**From:** Andrew Leon  
**Sent:** Tuesday, February 21, 2023 8:25 AM  
**To:** Ryan Harriman  
**Subject:** FW: Totally Against DSR22-014 Baskin Robbins Proposed 10-unit building

**From:** Sarah Fletcher <[fletchsa1@gmail.com](mailto:fletchsa1@gmail.com)>  
**Sent:** Sunday, February 19, 2023 7:04 PM  
**To:** Andrew Leon <[andrew.leon@mercerisland.gov](mailto:andrew.leon@mercerisland.gov)>; Jeff Thomas <[jeff.thomas@mercerisland.gov](mailto:jeff.thomas@mercerisland.gov)>; Planning Commission <[Planning.Commission@mercergov.org](mailto:Planning.Commission@mercergov.org)>; Design Commission <[Design.Commission@mercergov.org](mailto:Design.Commission@mercergov.org)>  
**Subject:** Totally Against DSR22-014 Baskin Robbins Proposed 10-unit building

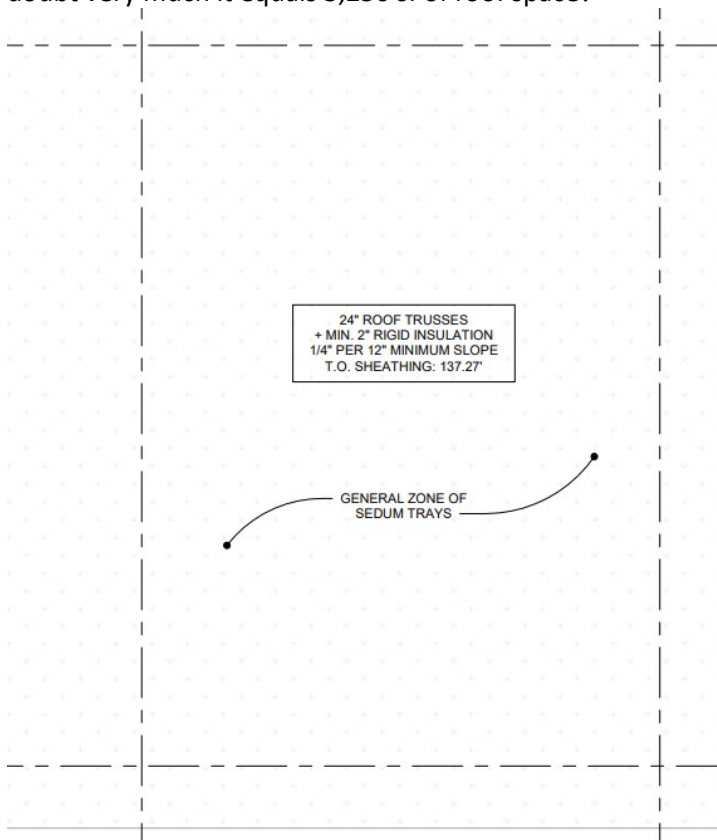
It says that 3,250 sf of sedum trays on the roof, but if you look at the plans on page 7, it does not show 3,250 sf of sedum trays, it shows a portion. And are you trying to say, that they can go across the road, buy a few trays of sedum and put them on the roof, and that is sufficient?

As I am a layman and don't know how to read plans, how much exactly is it showing? I

- a) And what happens if the greenery dies?
- b) That would mean that they are below their landscaping requirement, what happens if they fall below the required landscaping requirement?
- b) Is someone going to be watering the sedum?

If you look at the plans, it has a section of the roof as for the sedum trays on a portion and not even on the whole roof, I doubt very much it equals 3,250 sf of roof space?

Is the roof going to be sloped or flat? It is hard to tell.

Trees #8-10

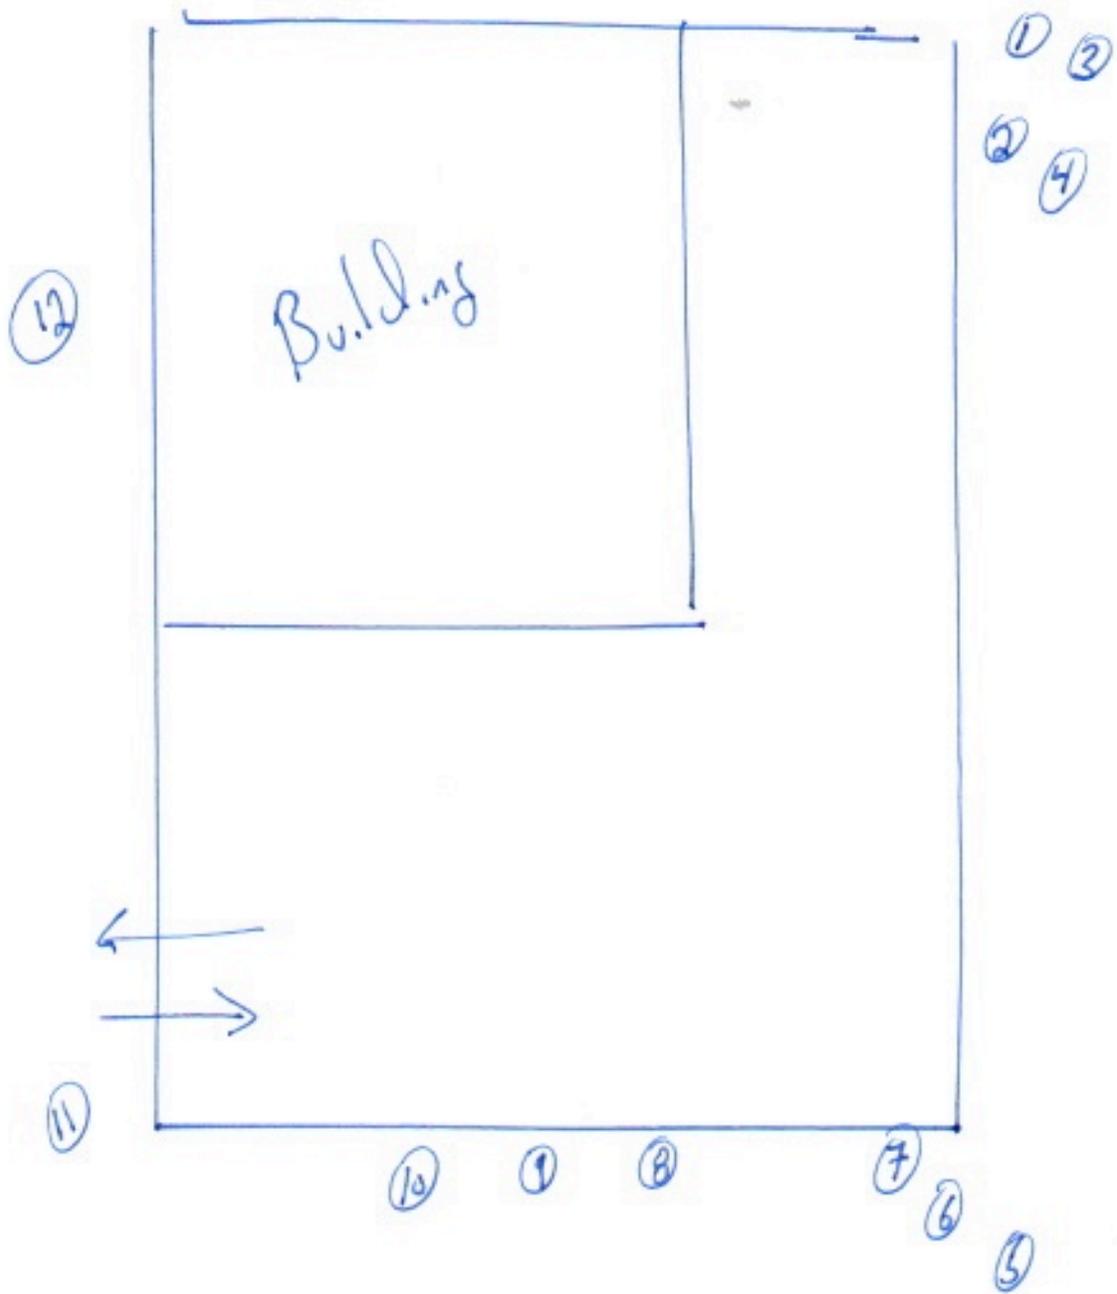
It states that trees 8 through 10 are to be removed, but if you look at the photographs, they are on City property, not even on the developer's property.

- a) What right do they have to remove any City trees regardless of whether they are significant or otherwise?
- b) Where does it say anything in the code that a developer can remove city-property trees? Please make sure that they do not remove any City right of way trees.
